CITY OF ALBUQUERQUE

March 22, 2019

**RE: Maverik – Unser/Los Volcanes
551 Silver Creek Rd. NW
Grading and Drainage Plan & Drainage Report
Engineer's Stamp Date: 03/19/19
Hydrology File: K10D023D**

ASI-001		
ENGINEER'S SEAL	 	MAVERIK STORE #NM-0115 UNSER AND LOS VOLCANES
		GRADING AND DRAINAGE PLAN
RONALD R. BOHANNAN P.E. #7868	 TERRA WEST, LLC 5571 MIDWAY PARK PL NE ALBUQUERQUE, NEW MEXICO 87109 (505) 858-3100 www.tierrawestllc.com	DRAWN BY pm DATE 3-17-2020 DRAWING SHEET # GR-1 JOB # 2018042

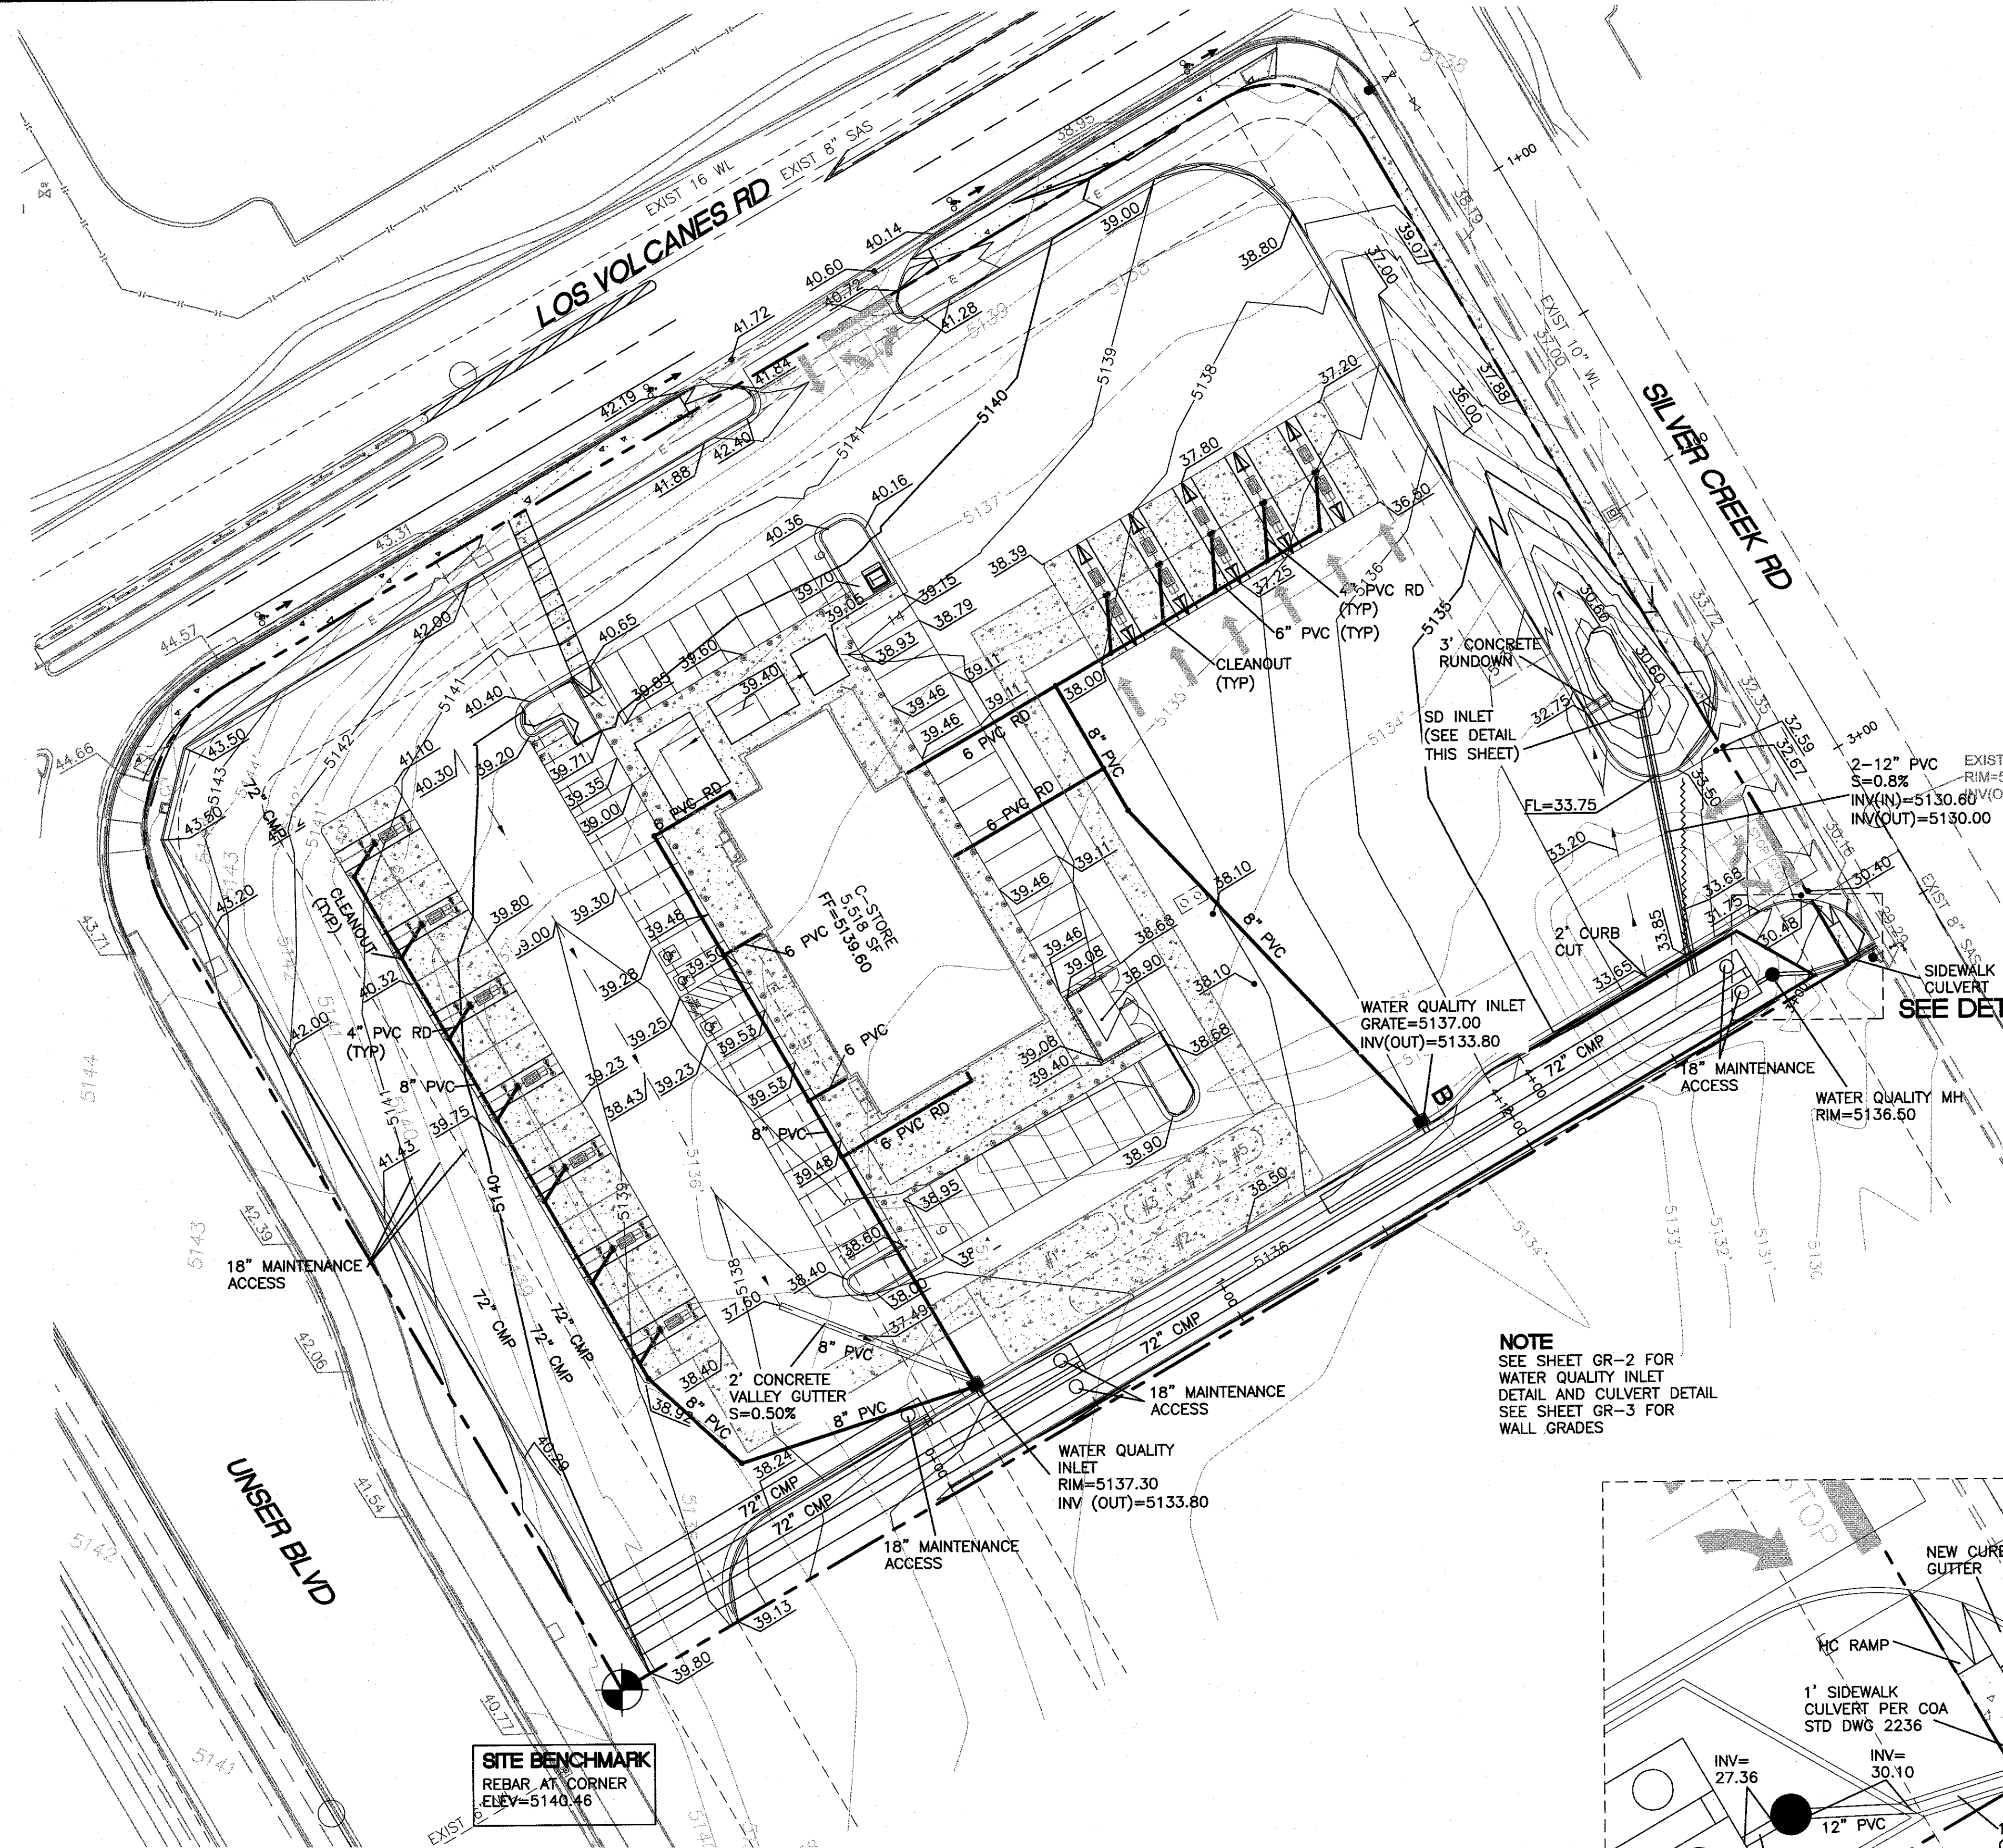
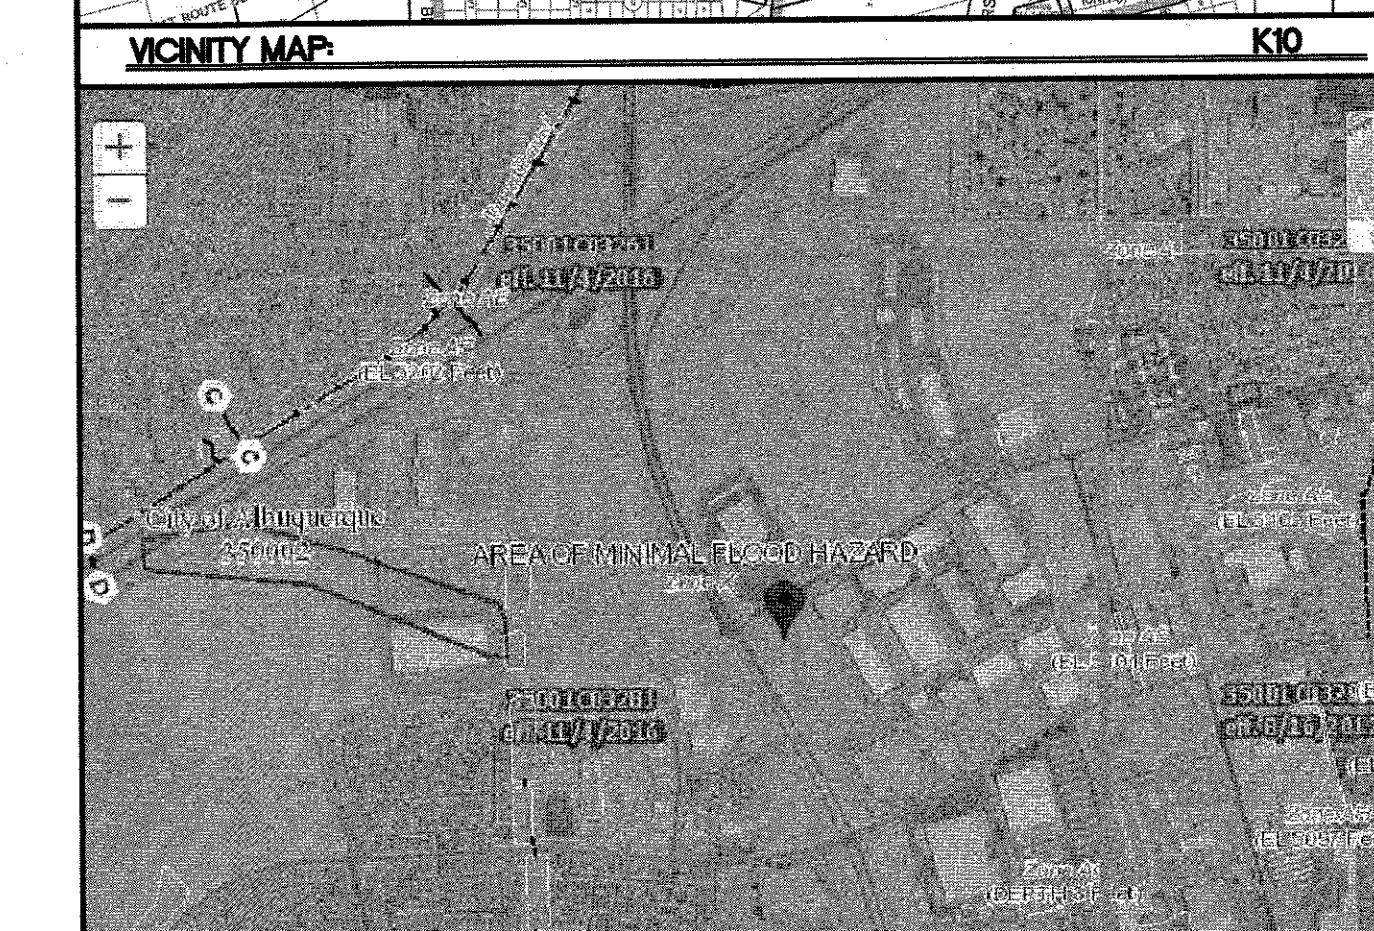
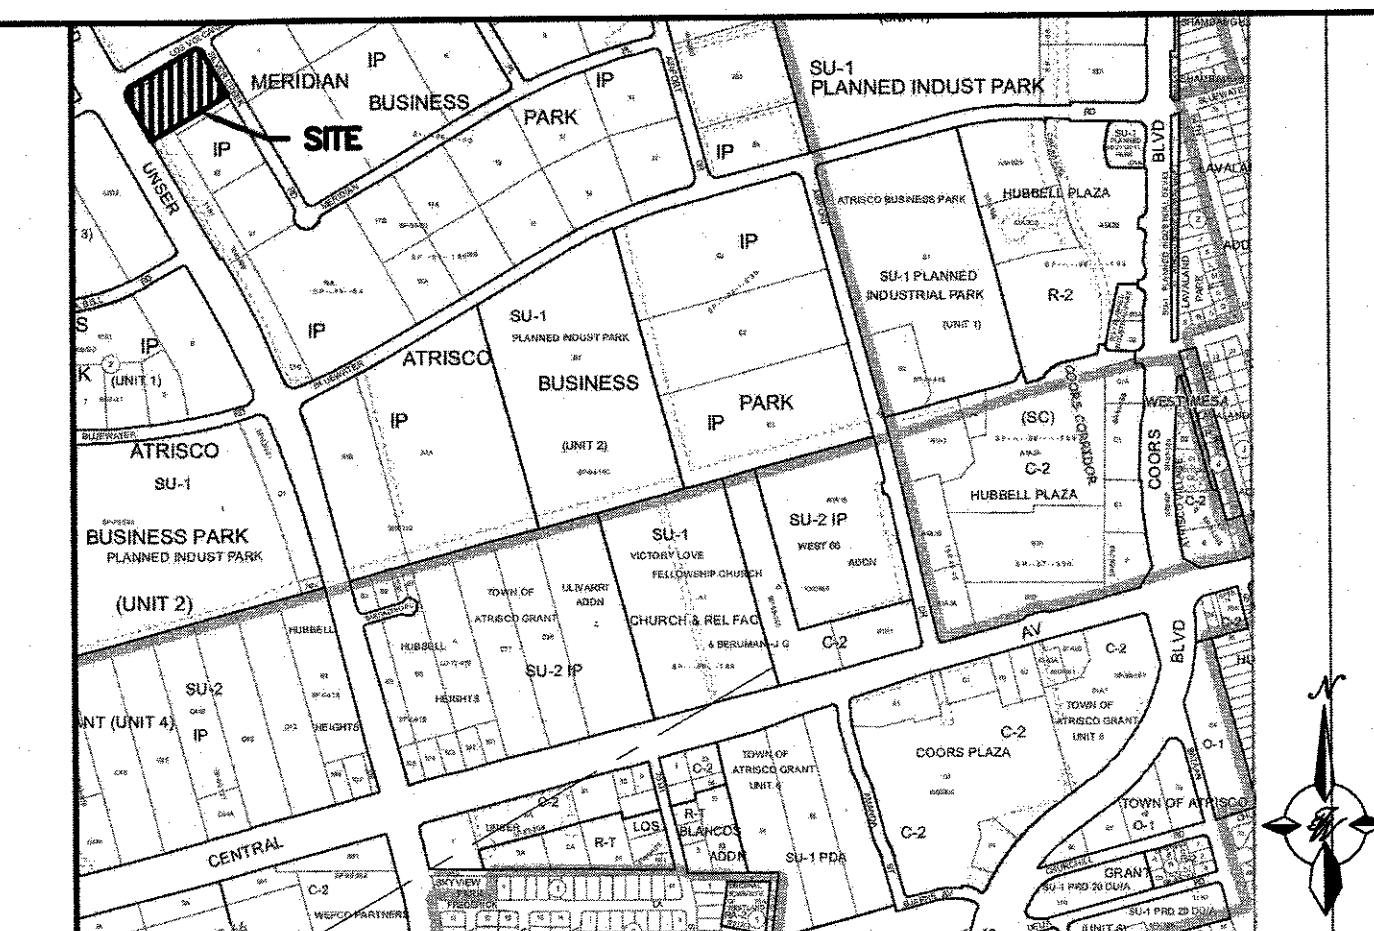
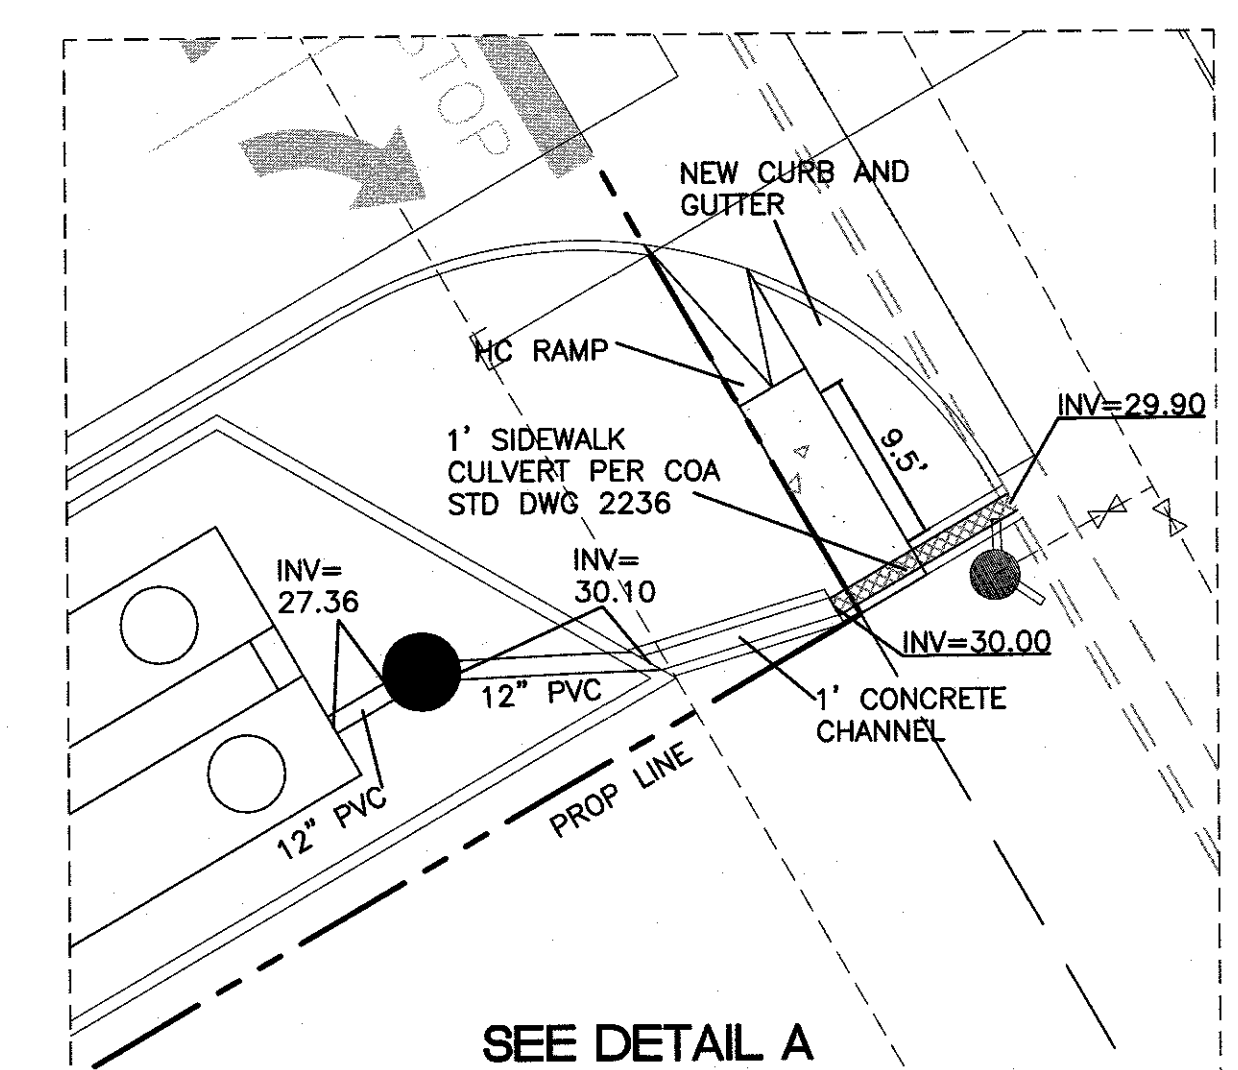
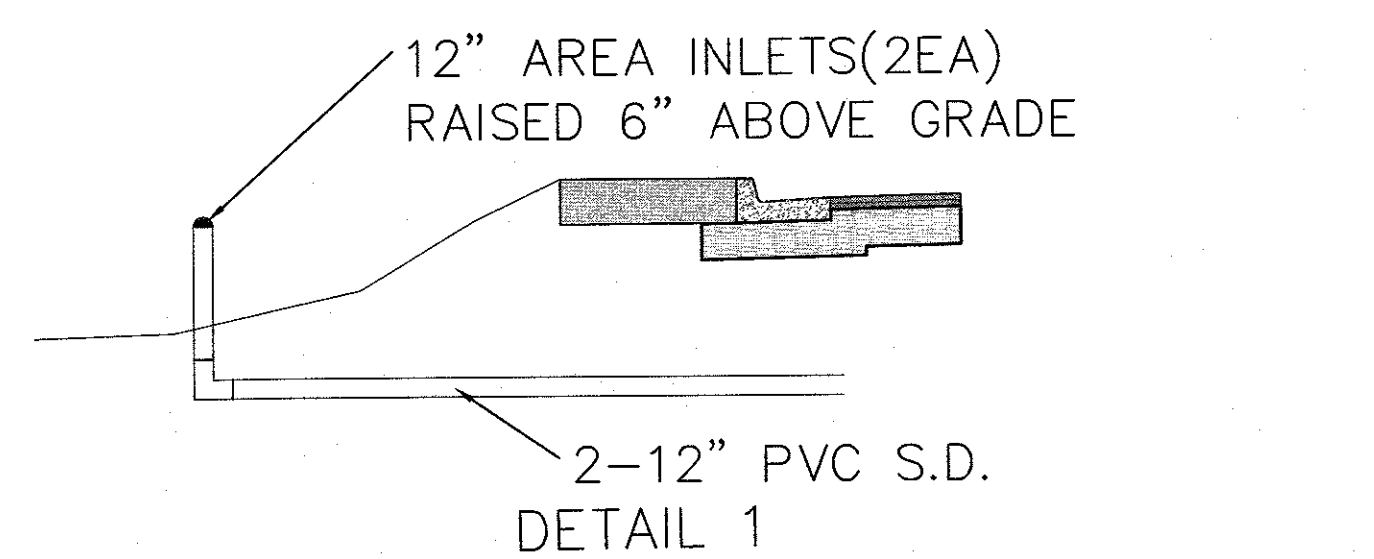
4. Grading Plan. Please provide the legal description of the property.
5. Grading Plan. Please provide the benchmark information for the survey topographic information provided.

6. Grading Plan. Is there existing grade information for the site? I just see flowline information along existing curbing within all three R.O.W. Also I need the topographic grades on the adjacent property to confirm that the proposed contours are tying into the existing contours and to ensure that there will not be any grading on the adjacent property.

CITY OF ALBUQUERQUE

7. Grading Plan. For fueling stations, demonstrate control of oil from vehicle parking areas per DPM Chapter 22.9.E, Table 1. Please provide a detail of how you are handling the surface runoff per this section.

8. Grading Plan. Please ensure that the site plan is what has been approved by Transportation. It appears that the southeast curb return is over the property line.

9. Grading Plan. In Section B-B, please show the inlet and the pipe from the inlet to the pond. Also call out the railing.
10. Grading Plan. Per DPM Ch. 22.5.B, grading and construction of retaining walls at or near the property line must demonstrate that the adjacent property is not damaged or its use constrained. Any such encroachment by the wall or grading must be accompanied by written permission of both landowners. Please ensure the footers do not go in either the adjacent property or R.O.W. without the written permission.

14. Grading Plan. Please provide a blowup area for the 2 ft concrete channel and sidewalk culvert with all grade information. This is for clarification of the location and buildability of them. Also please call out CoA drawing #2236 for the sidewalk culvert.

15. Grading Plan. Please show a section for the 2 ft concrete channel.
16. Grading Plan. Please shift the callout for the 2-12" pvc pipes into the roadway so that it can be readable.

17. Grading Plan. Please ensure the sidewalk culvert is not under the ADA ramp. This can be placed right after the ramp. This is a very tight area and the driveway may have to be shifted in order to build both the sidewalk culvert and the ADA ramp.
